September 9, 2025

RE: Take 5 Oil Change
2030 Gibson Blvd. SE
Traffic Circulation Layout
Engineer's Stamp 08-28-23 (M15-D021E)

Please find below our responses addressing the City of Albuquerque TCL 2nd Submittal Review comments for the proposed project located at 2030 Gibson Blvd. SE.

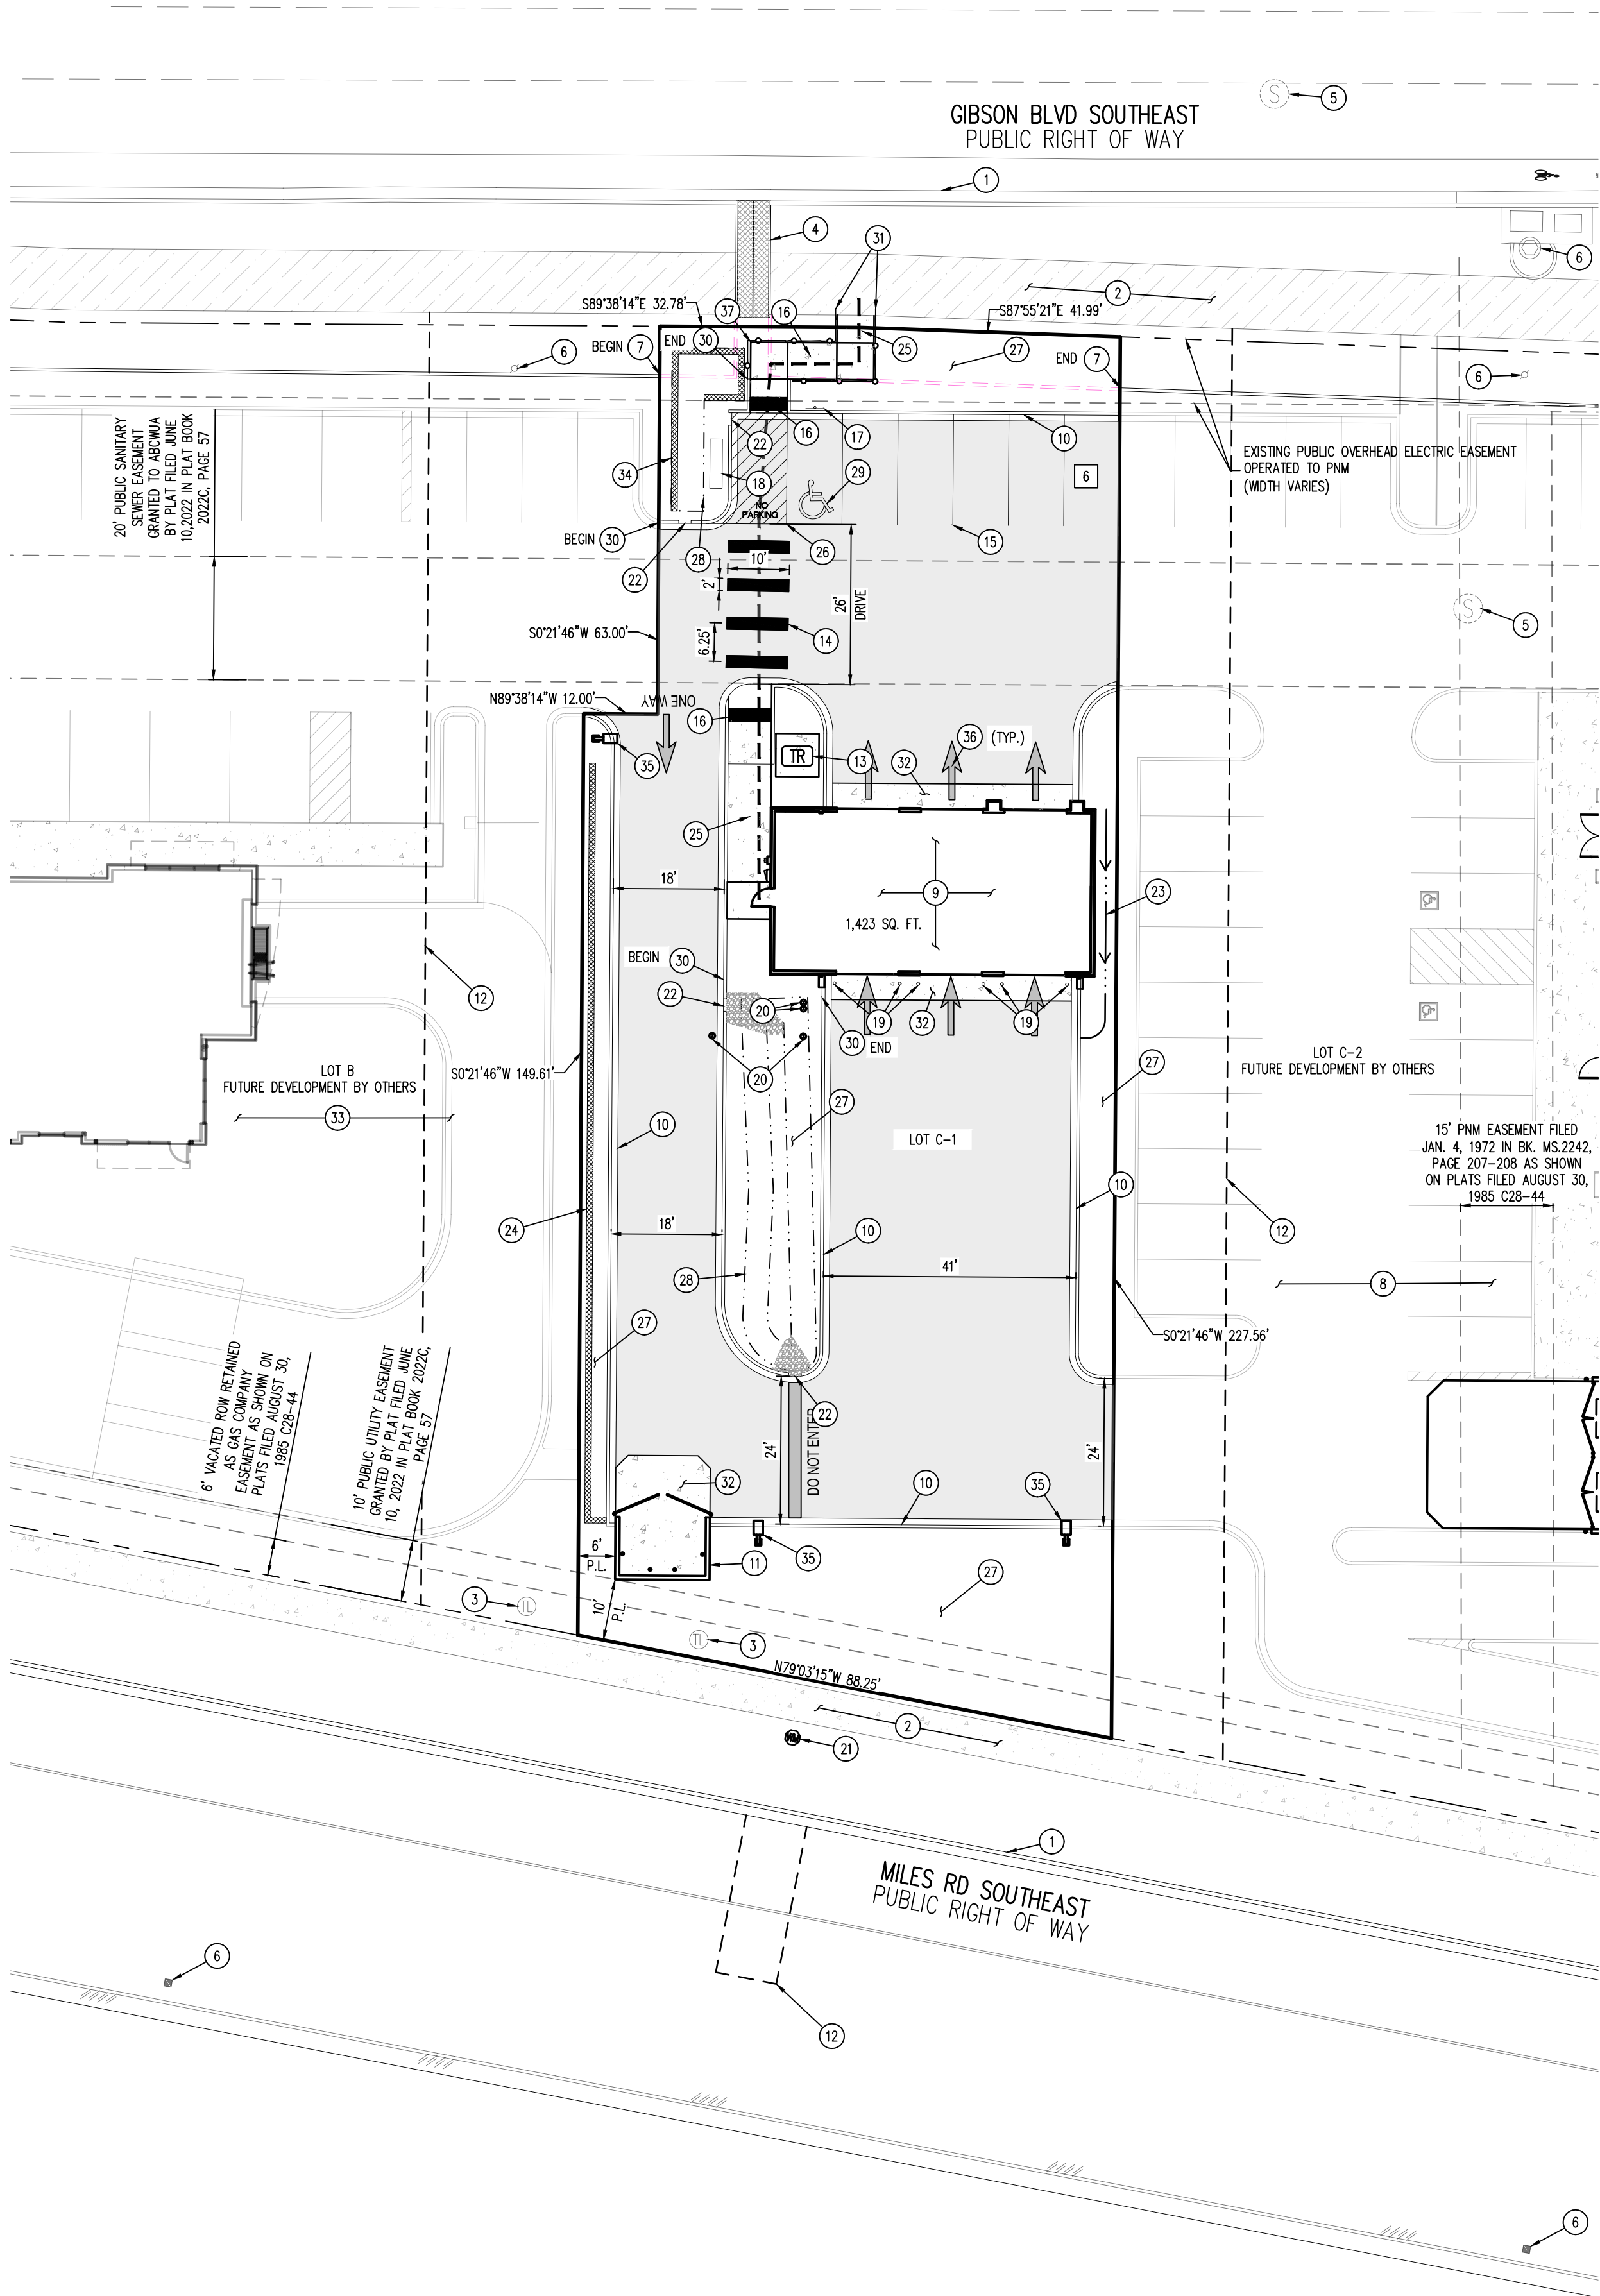
2. "DO NOT ENTER" and "STOP" signage and pavement marking must be provided at the building exit and at the one way drive lane.

4. Please contact Code Enforcement (Concetta Trujillo at cmtrujillo@cabq.gov) to confirm whether a motorcycle parking space and a bike rack are required.

Response: Requested signage and pavement markings have been added to plan.

Response: Motorcycle parking, bike rack, and associated have been added to plan.
